# KITTITAS COUNTY

### MEMORANDUM

SUBJECT: Zentz Short Plat SP-13-00003 and Rezone RZ-13-00001

#### The following shall be conditions of preliminary approval:

SHORT PLAT PREPARED FOR TERESA ZENTZ A PORTION OF THE NW 1/4 OF SECTION 20, TOWNSHIP 18 NORTH, RANGE 18 EAST, W.M.		
KITTITAS COUNTY DWN BY DLP/GW	DATE 03/2013	JOB NO. 13017
CHKD BY DLP	SCALE 1" = 100'	SHEET 1 OF 2

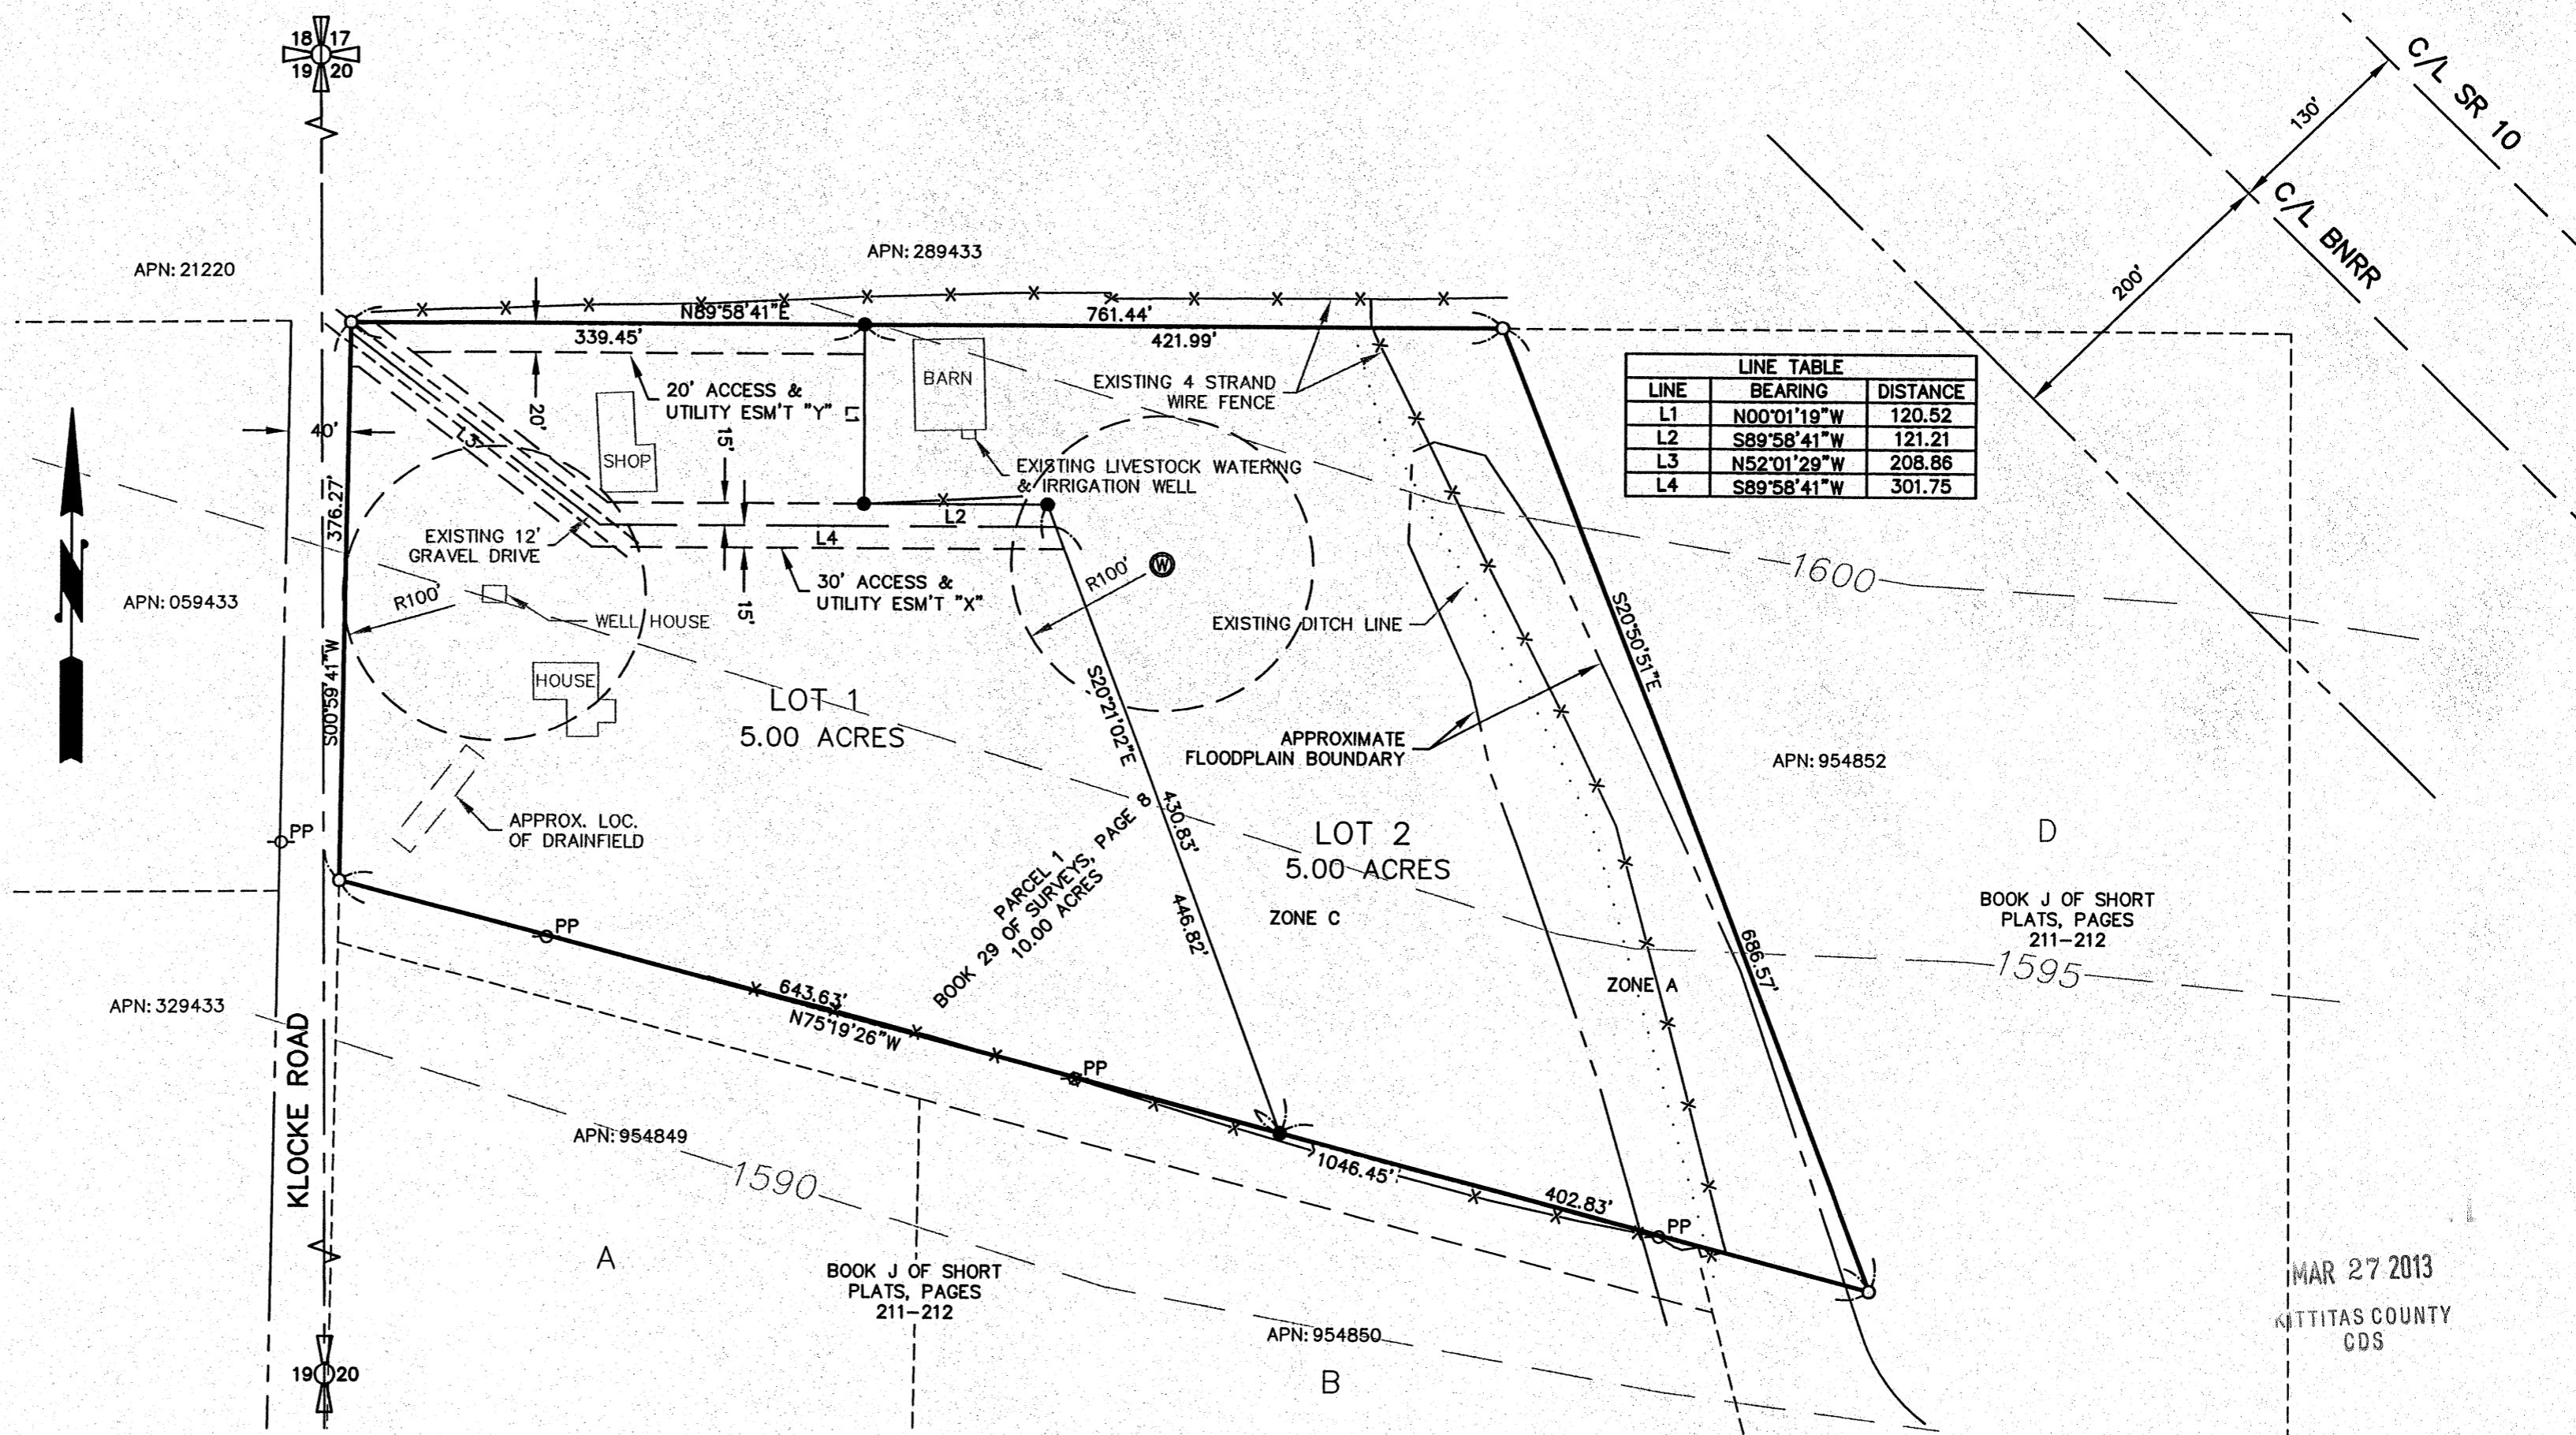
1. Joint-Use Driveway: A joint-use access shall serve no more than two tax parcels. See Kittitas County Road Standards, 9/6/05 edition.
  - a. Access easements shall be a minimum of 20' wide. The roadway width shall have a minimum width of 12'.
  - b. The surface requirement is for a minimum gravel surface depth of 6".
  - c. Maintenance of driveway approaches shall be the responsibility of the owner whose property they serve. The County will not maintain accesses.
  - d. Any further subdivision or lots to be served by proposed access may result in further access requirements.

Single-Use Driveway: A single-use access shall serve no more than one lot. See Kittitas County Road Standards, 9/6/05 edition.

- a. The roadway shall be a minimum of 8' wide with gravel surface.
  - b. Maintenance of driveway approaches shall be the responsibility of the owner whose property they serve. The County will not maintain accesses.
  - c. Any further subdivision or lots to be served by proposed access may result in further access requirements.
2. Private Road Maintenance Agreement: The applicant shall meet all applicable conditions of any pre-established or required Private Road Maintenance Agreements.
  3. Lot Closure: It is the responsibility of the Professional Licensed Surveyor (PLS) to ensure the lot closures are correct and accurate.

4. Access Permit: An approved access permit shall be required from the Department of Public Works prior to creating any new driveway access or performing work within the county road right of way.
5. Addressing: Contact the Kittitas County Rural Addressing Coordinator at (509) 962-7523 to obtain addresses prior to obtaining a building permit. A parcel cannot receive a building permit or utilities until such parcel is identified with a 911 address.
6. Mailbox Placement: Mailboxes must be approved by U.S. Postal Service. Mailbox locations are site specific. Contact your local Post Office for location and design standards before beginning construction.
